## Rampion 2 windfarm proposal EN010117

Janine Creaye IP no 20045132

### Our June assessment of Talbot & Baker II site at Crateman's Farm Cowfold

Contains OS data © Crown Copyright and database right 2020
 © Crown Copyright. All rights reserved. Licence number AL100001776.

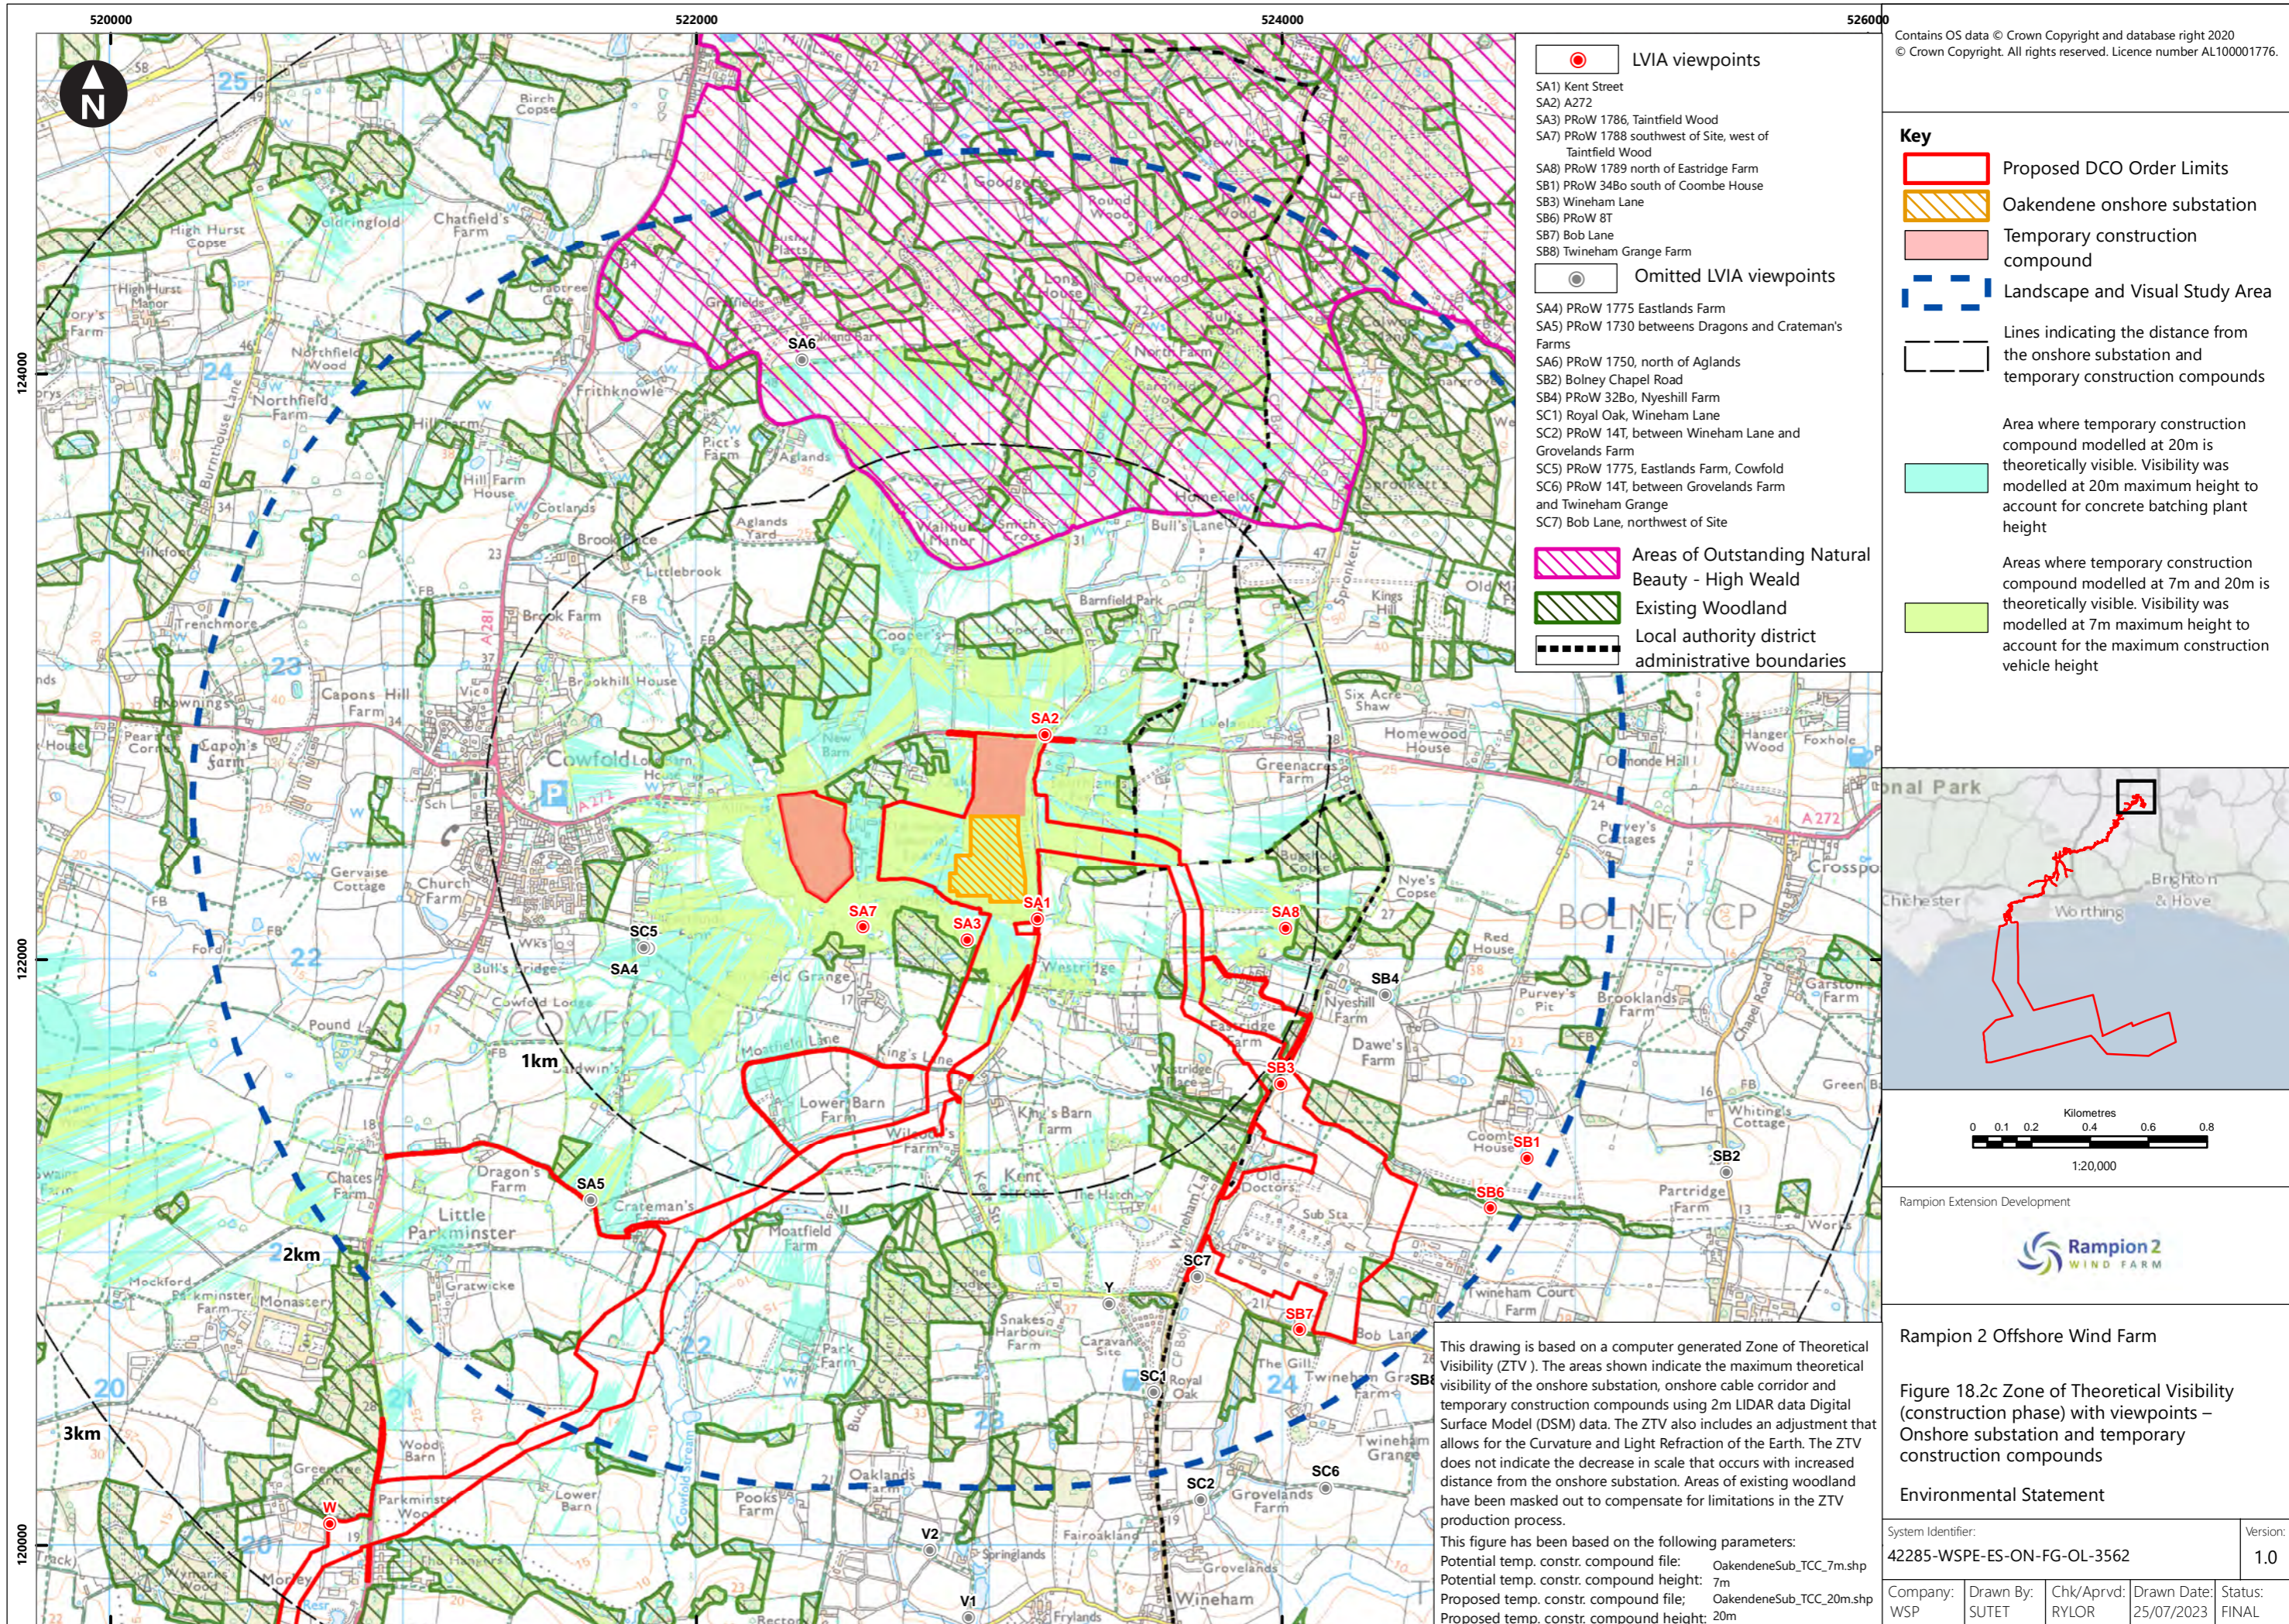
From SA1 REP4-026  
not showing ground shaping, vegetation  
and tree loss or H505 cleared to 20m

- Where are the view point visualisations to show: the actual locations of Access points A61, A64 with the tree loss incurred, the impact of clearing of H505 to 20m, the widening of the junction with A272 with the tree and scrub loss incurred and the concreting over of the verges for the 4 passing places in Kent Street? The deadline 4 images (REP4-026/027) are all irrelevant for Kent Street, out of phase with the process, and very misleading.
